**RESPONSE TO COMMENTS:**

**2/23/21**

**Permit Application Number: 2001-170**

**9027 SE 60th. St.  
Mercer Island, Wa. 98040**

**UPPER FLOOR FRAMING PLAN**  
SCALE 1/4" = 1'-0"

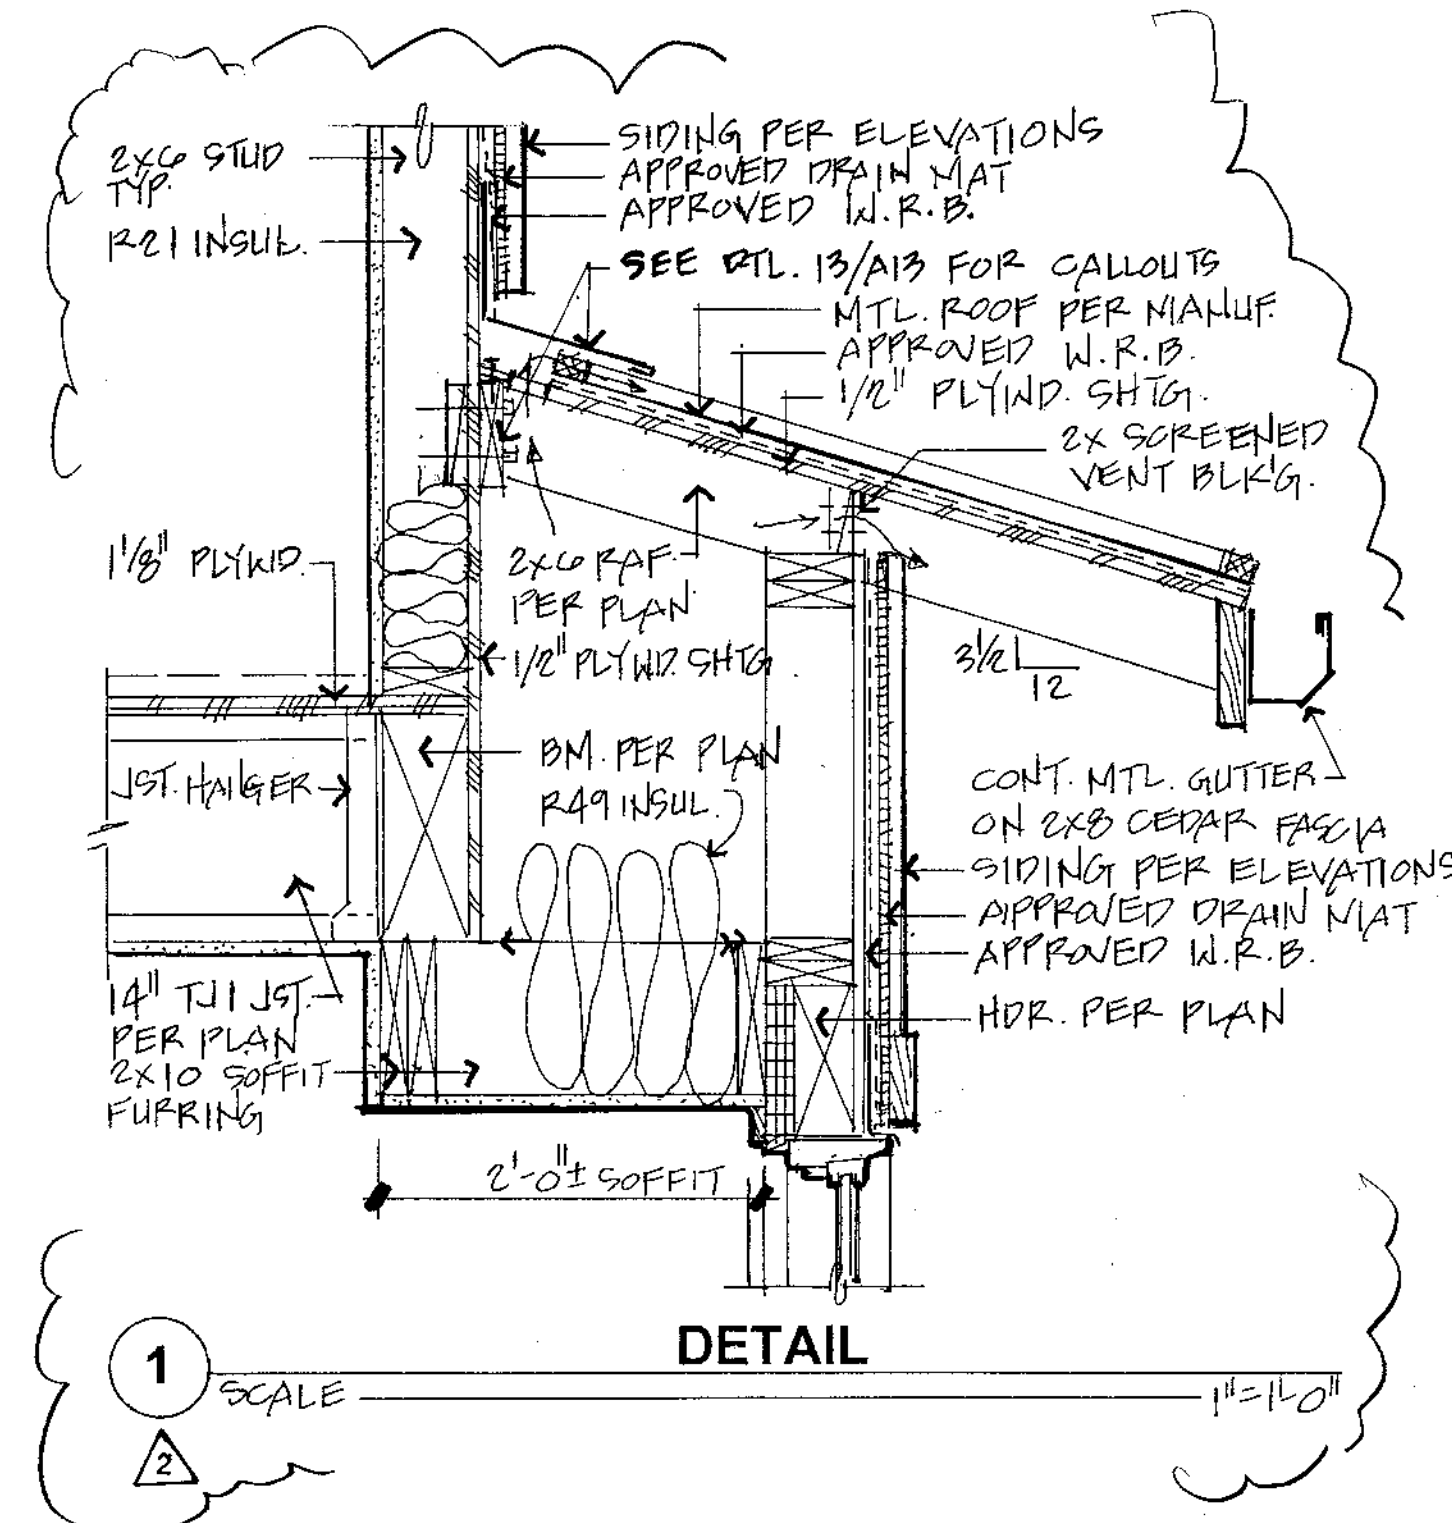
Page 13:  
Number 1: Added sheet A8  
Number 2: Added sheet A8, see structural  
Number 3: Added sheet A8, see structural  
Number 4: Increased stud columns to (4) 2x 6 sheet A8, see structural  
Number 5: Added detail 1/A8

**SECTION AA**  
SCALE 1/4" = 1'-0"

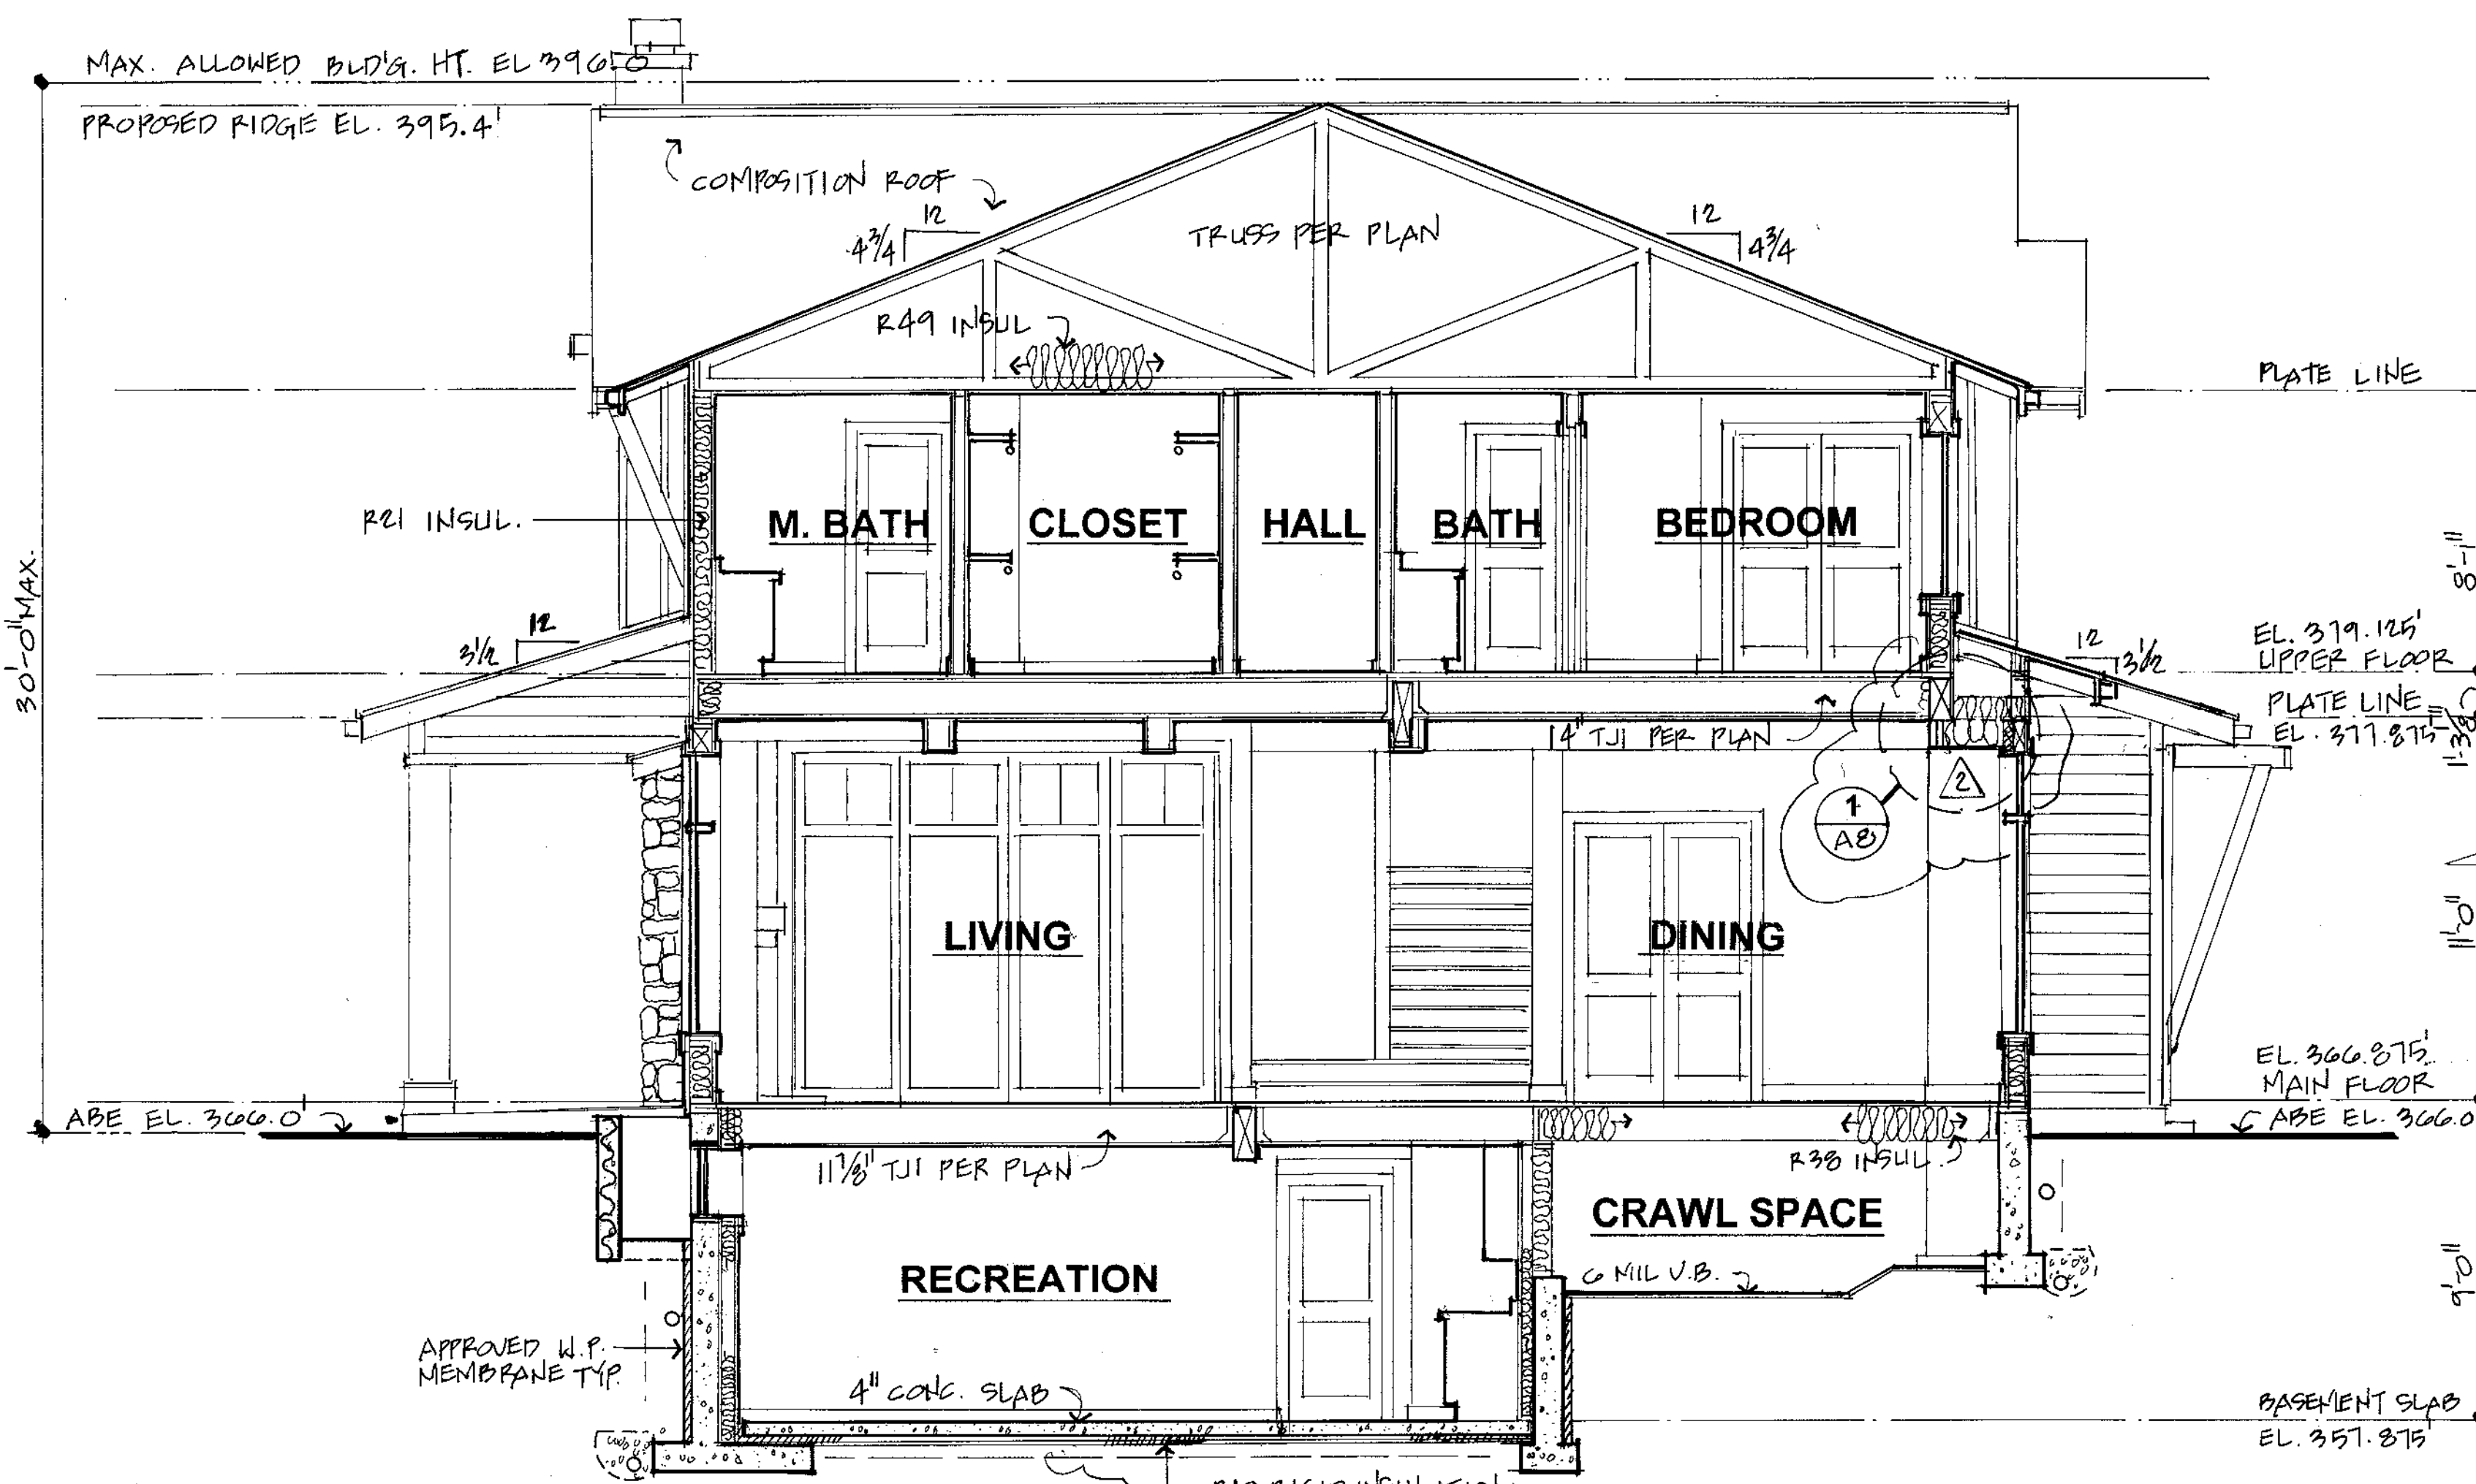
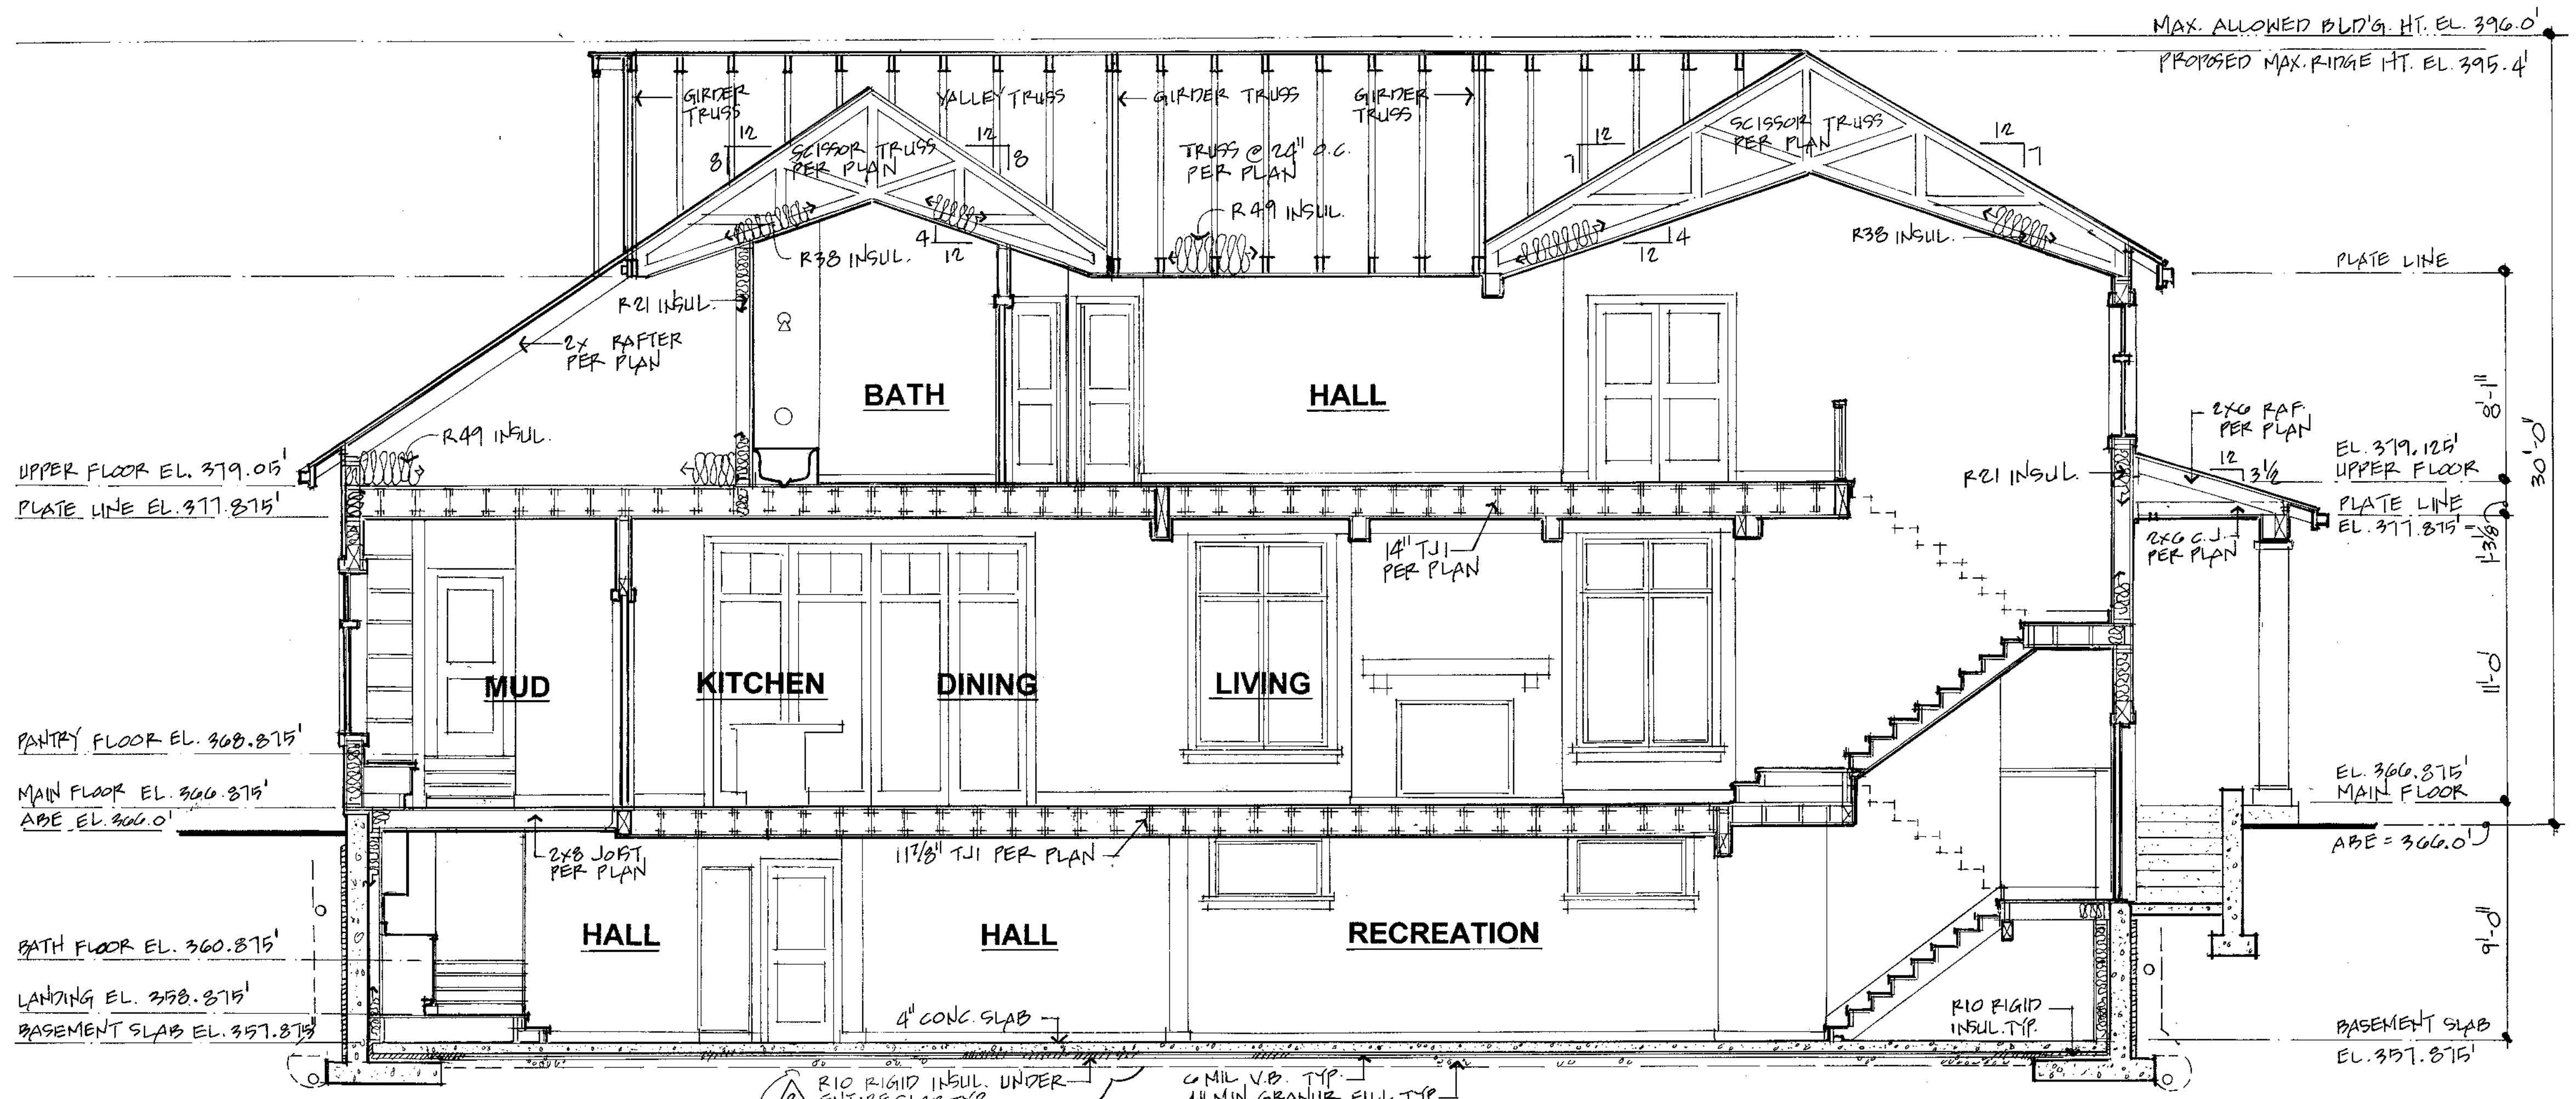
Page 17:  
Number 1: Added detail 1/A8  
Number 2: Added note to detail 1/A13, also shown on sections AA, BB, & CC  
Number 3: Added note to detail 1/A13, also shown on sections AA, BB, & CC

**Number 6: Added to detail 1/A13 and sections AA, BB, & CC**

**12** SCALE 1/2" = 1'-0"

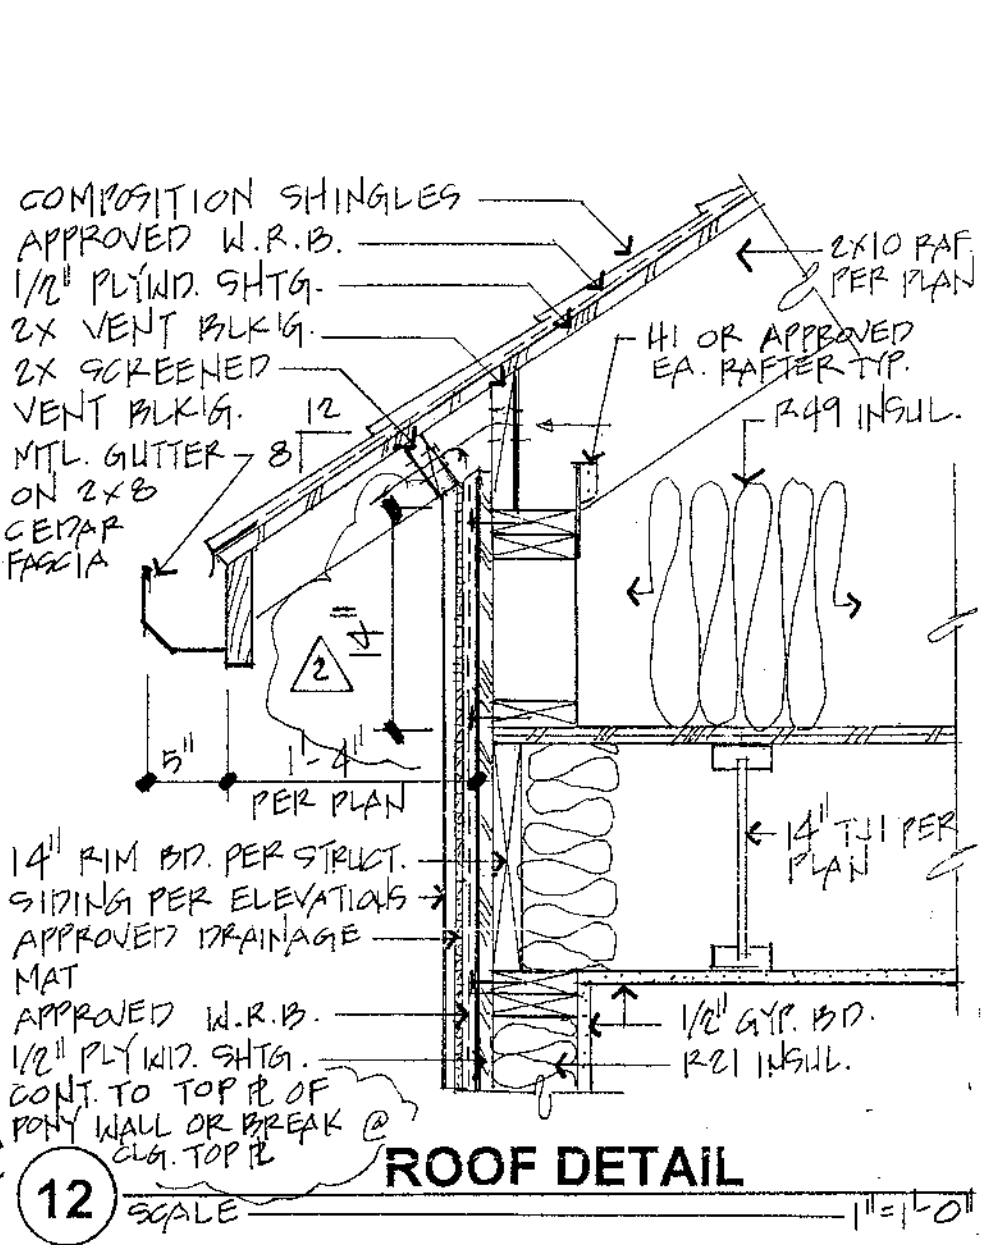
Page:  
Number 1: Note is already shown on sheet A5 floor plan notes, added to dtl.  
15/A13  
Number 2: Added to detail 13/A13, also see structural  
Number 3: Added dimension to detail 12/A13  
Number 4: Added blocking to detail 11/A13  
Number 5: Comment is blank.
